Our ref: DOC21/554455-3

### **Mount Pleasant Continued Operations, Muswellbrook LGA (SSD 10418). Review of Response to Submission Report.**

**Dr Samantha Higgs**

Senior Team Leader  
ACH Regulation, North  
Heritage NSW  
Department of Premier and Cabinet  
9 August 2021

Figure 13: Aboriginal Cultural Heritage Sites

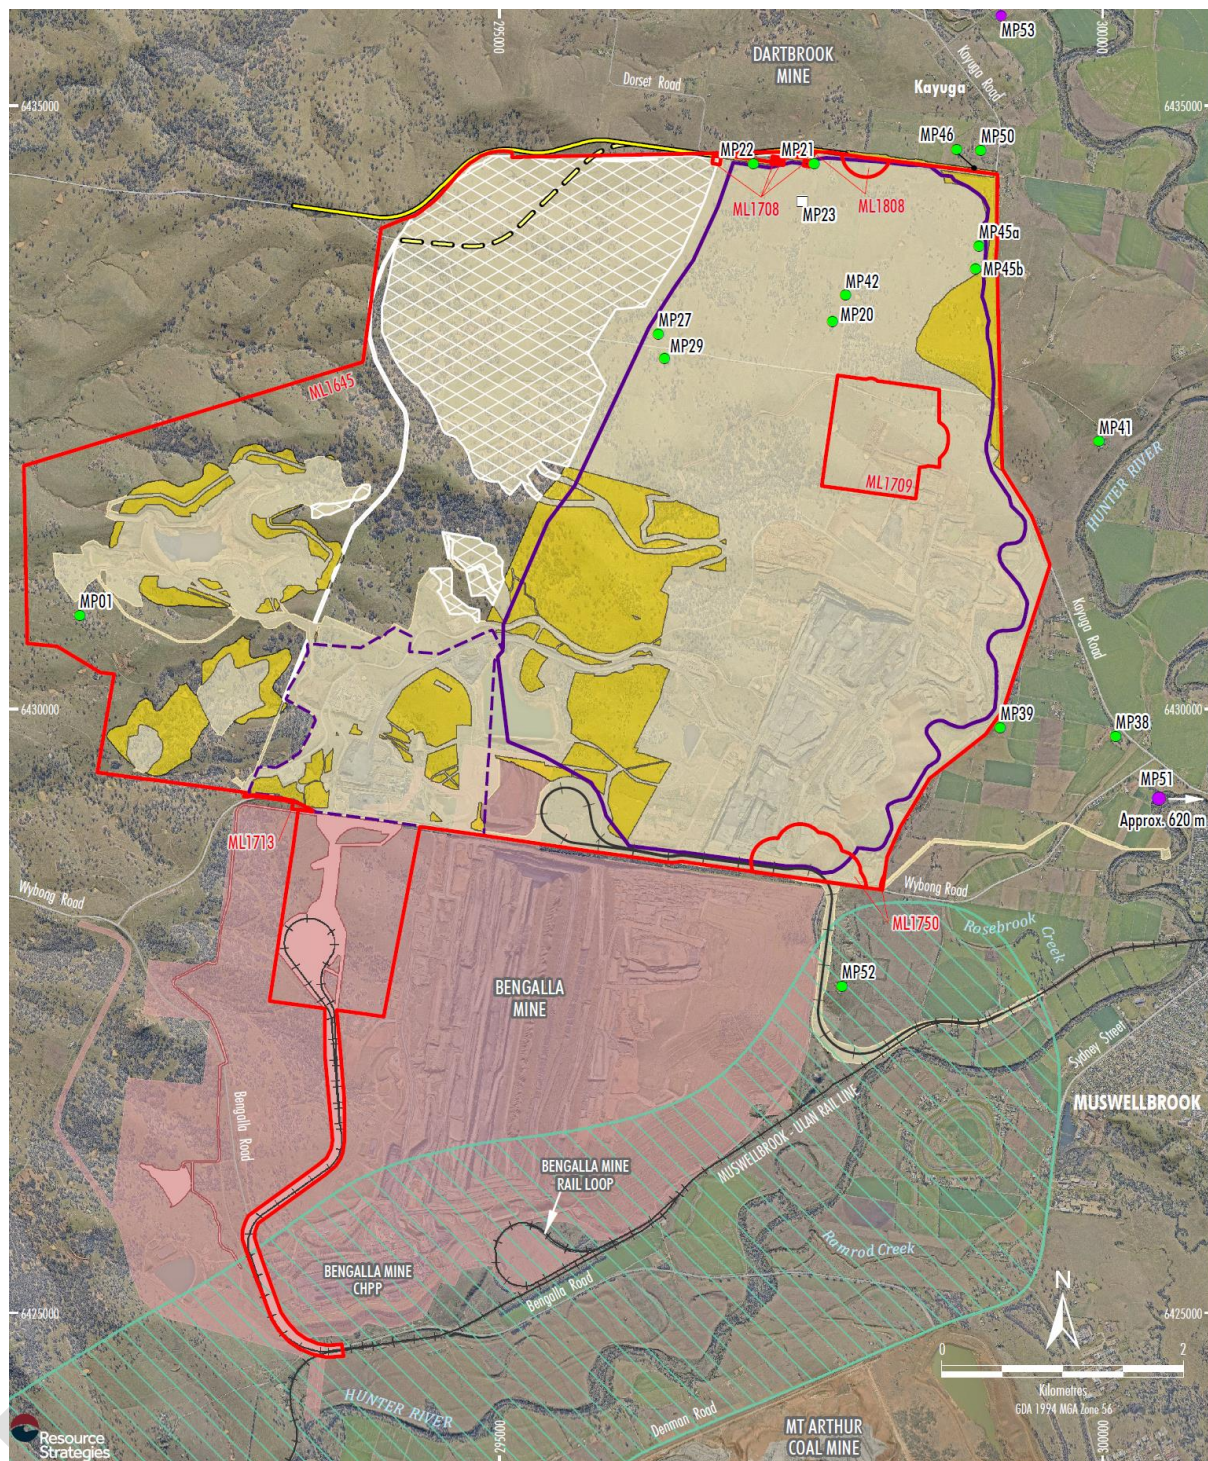
**Recommendation 3:** Determine if scarred trees described in Figure 10 of the RTS are Aboriginal culturally modified trees with reference to the *Field Guide for Identifying and Recording Aboriginal Scarred trees in NSW (DEC 2005)*.

The RTS state that several of the trees, that the HNSW submission requests re-assessment, are outside of the MPO project boundary (and responsibility) and yet, the HNSW submission is based on the information provided by the MPO ACH assessment (the EIS). Figure 10 of the RTS place several of the trees within the adjoining Bengalla Mining Lease whilst some are located within an approved water pipeline corridor which, HNSW understand, carries dual interest for the Mt Pleasant project and Bengalla Mine project.

To conclude this matter HNSW request that the proponent carry out or, facilitate, a determination of the trees as previously requested based on, prior knowledge of their

existence. Assessment of the trees must refer to the, *Field Guide for Identifying and Recording Aboriginal Scarred trees in NSW (DEC 2005)*.
